Submissions Report

Mixed-Use Development with In-Fill Affordable Housing

2-6 Pilgrim Avenue and 11-13 Albert Road, Strathfield

SSD-80432461

ALBERT ROAD NATURAL VENTILATION PLENUMS

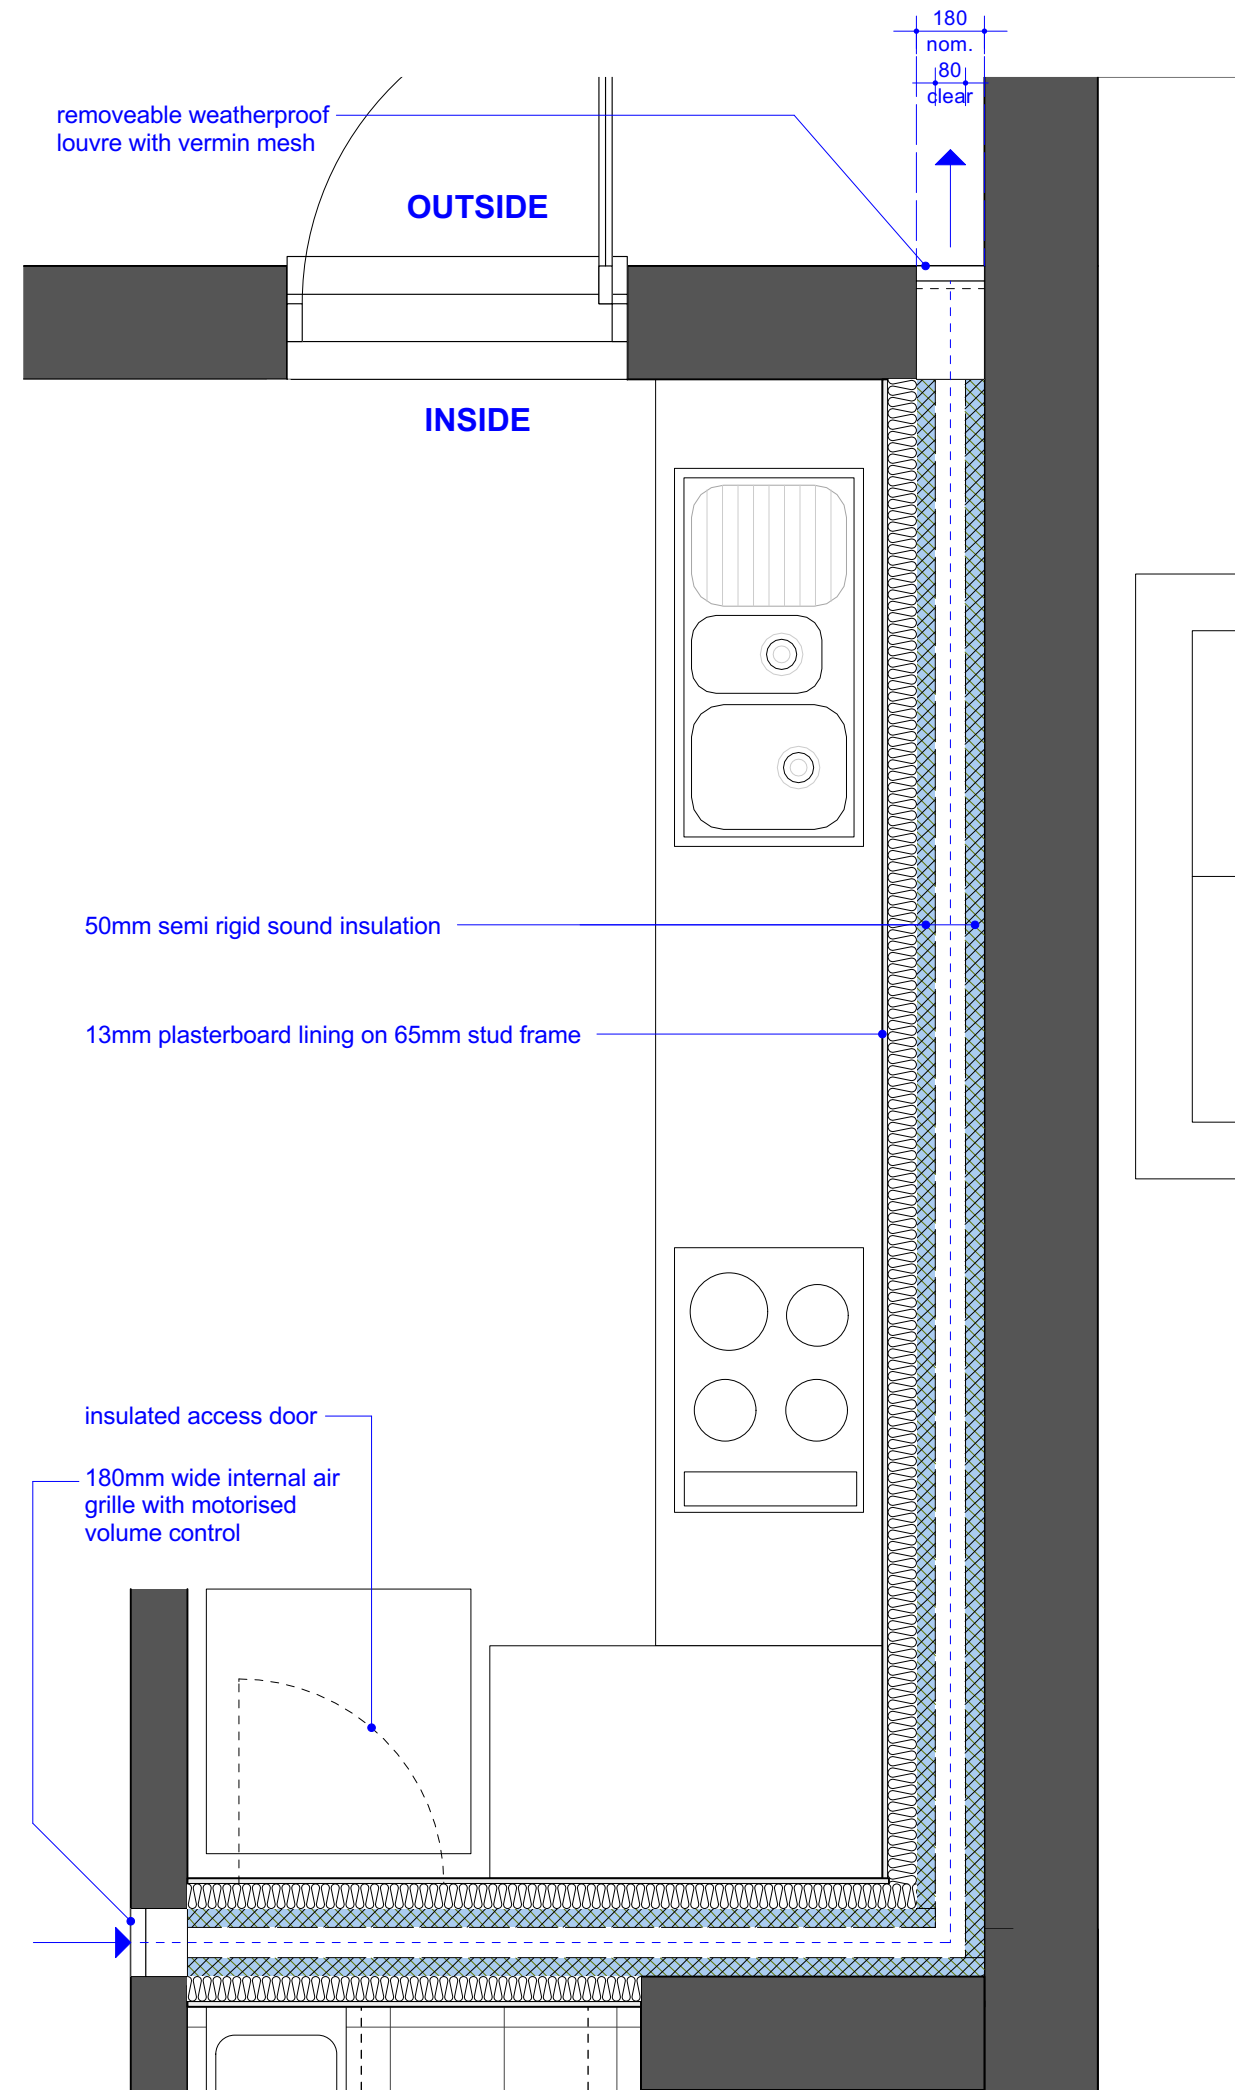
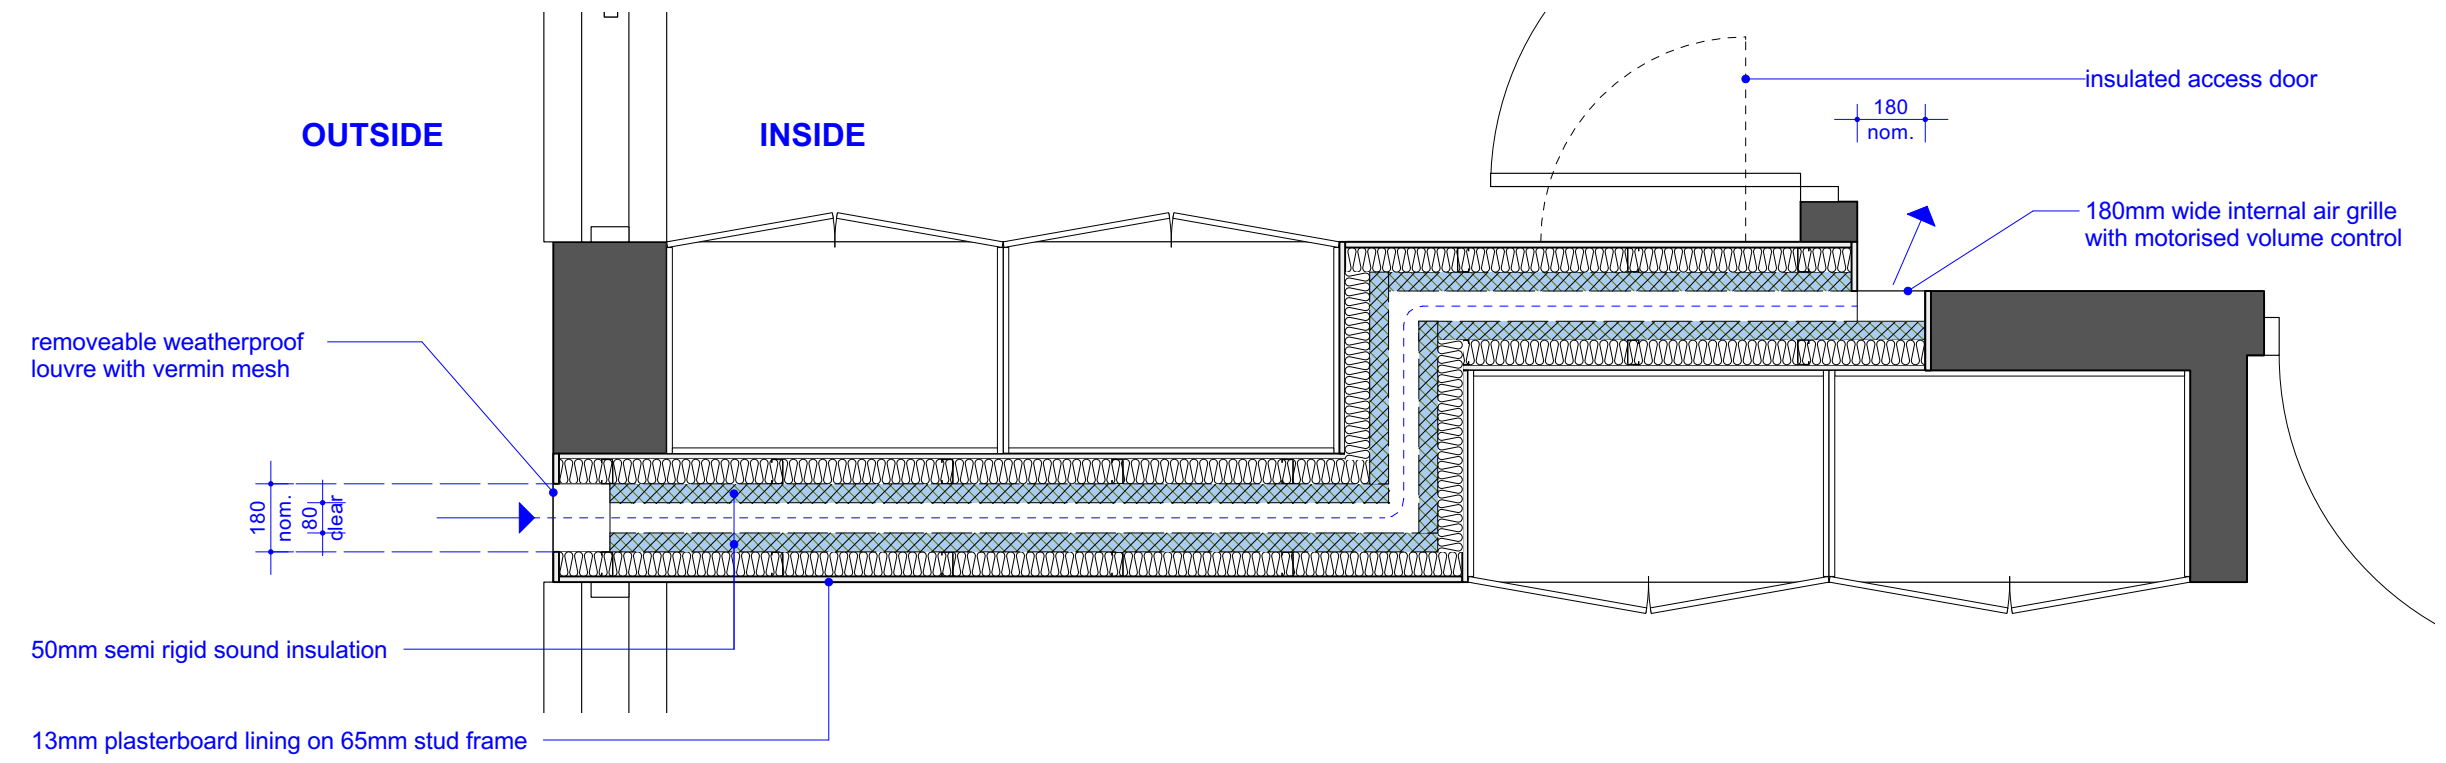
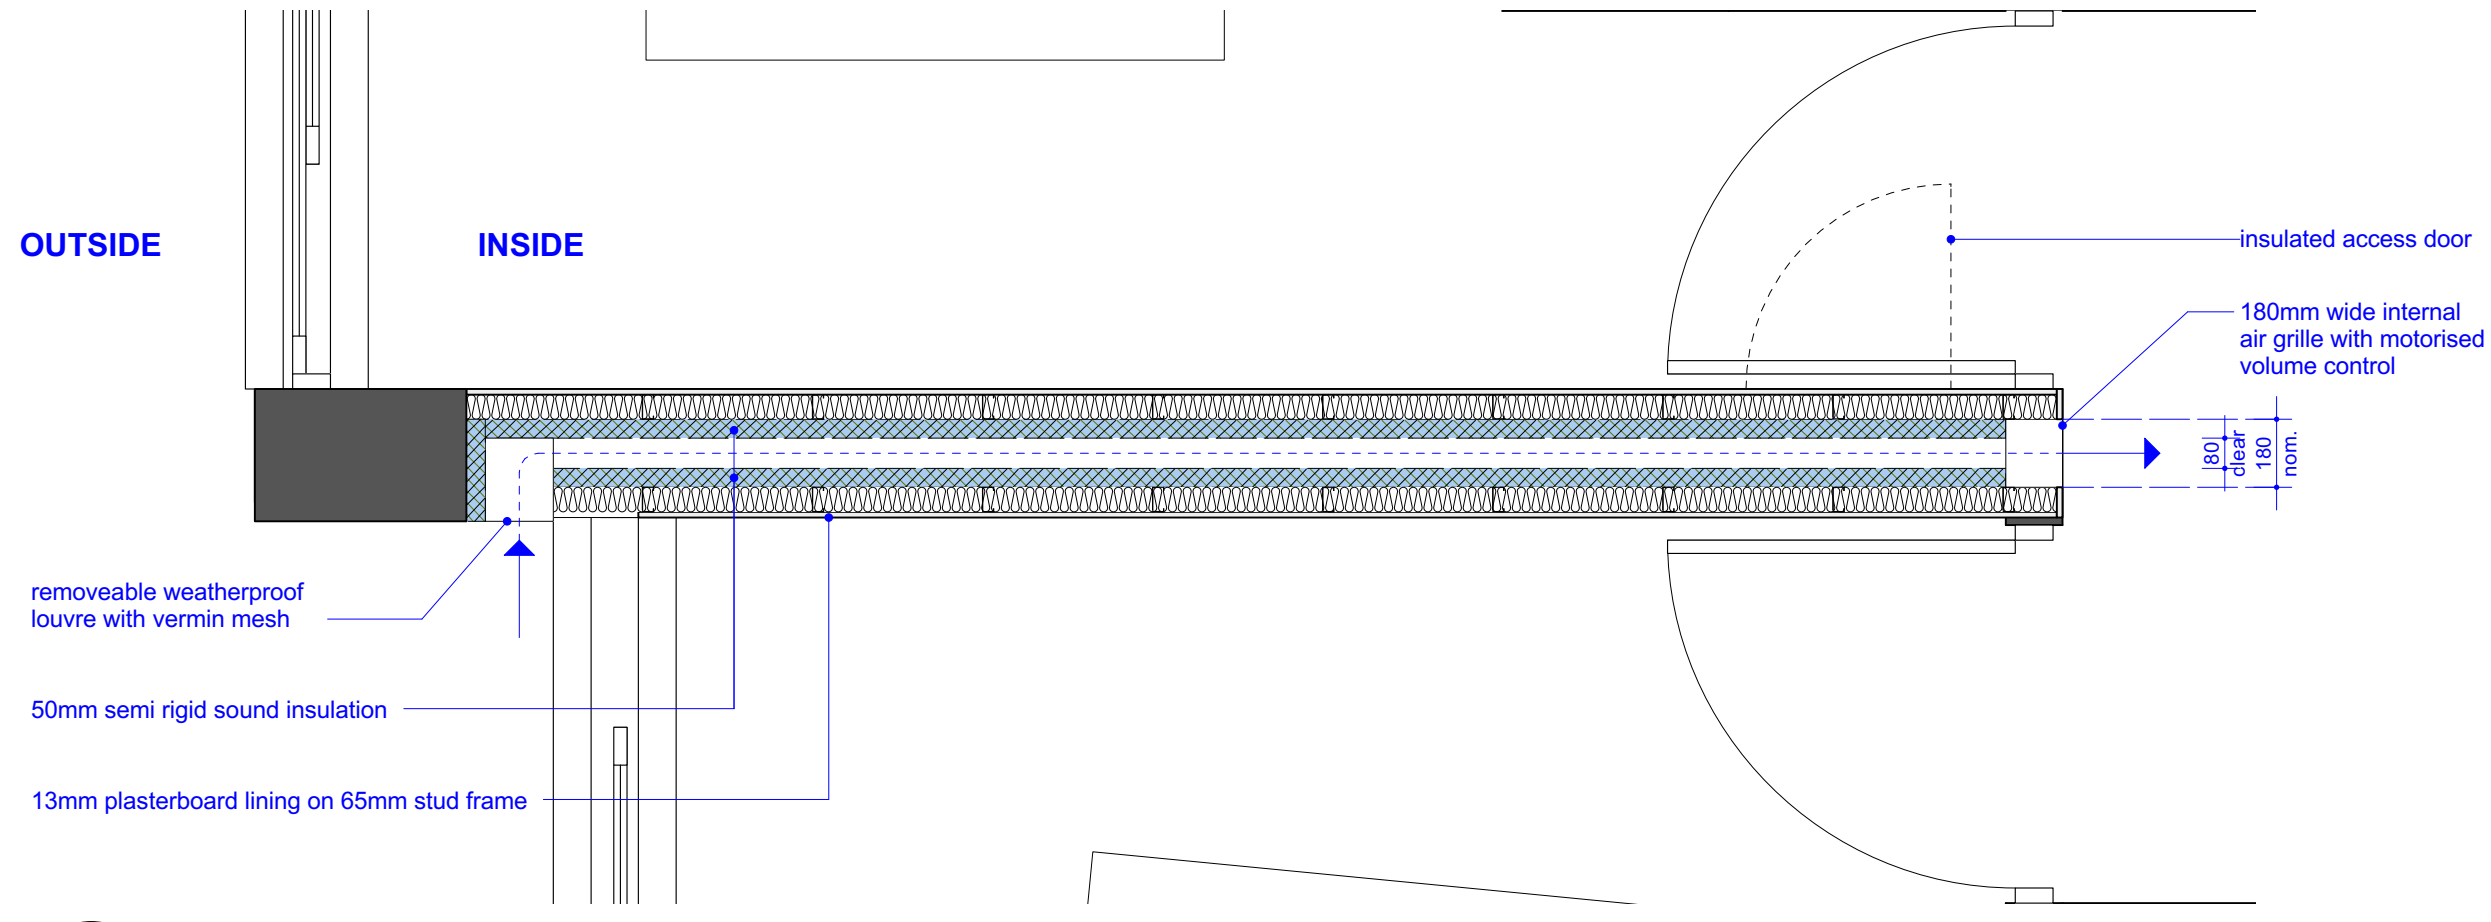
Matter Raised	Applicant Response
• Council does not support cross-ventilation via plenums. It is strongly recommended that apartments are converted (where possible) into 2-storey 3+ bedroom units in order to achieve the following: - Cross-ventilation (single aspect 2-storey is considered cross-ventilated in the ADG - Increase the % of 3-bedders. 7% is not close enough to a minimum 10% in the ADG, Homebush TOD's 20% mandate and Strathfield councils own strategic plan.	<i>Guideline.</i> Refer to DA0652.1 of the updated Architectural Drawings (Appendix B) for further details. The use of plenums to achieve natural and cross ventilation in high rise developments is a widely accepted industry practice supported by both local government and the Land & Environment Court. Most developments of the scale of this project rely on some form of plenum for a limited number of units. In this project, of the 96 apartments within the first nine storeys of the development only three (3) units, Units A 013, A 023 & A033, (2%) rely on the use of plenums for natural and cross ventilation to comply with ADG minimum requirement that 60% of units be naturally cross-ventilated. That is, the use of plenums has been limited to a very small proportion of units and applied only where necessary. A further nine (9) units (the units facing Albert Road) incorporate a combination of operable windows and plenums to achieve cross ventilation in all conditions. The use of plenums is a widely accepted mechanism for delivering natural ventilation to high density urban developments. Windtech, the ventilation consultants on the project, have reviewed the proposed unit configuration and plenum design and confirmed that the plenums will provide sufficient ventilation to meet the objectives of the ADG. The use of plenums has been limited to a small proportion of units and applied only where necessary, ensuring full compliance while preserving the integrity of the overall apartment mix. Multiple detailed wind tunnel studies have been undertaken to verify the effectiveness of horizontal plenums for use as natural cross-ventilation. These studies have confirmed the minimum sizing requirements to ensure their effectiveness as mitigation devices. Previously approved SSD projects which include plenums to achieve cross-ventilation that Windtech has worked on include 136 - 148 New South Head Road, Edgecliff (SSD-77608714) and Hills Showground Precinct East (SSD-62802207). Note that we have proposed the inclusion of horizontal plenums in numerous other SSD and non-SSD projects which are yet to be determined.
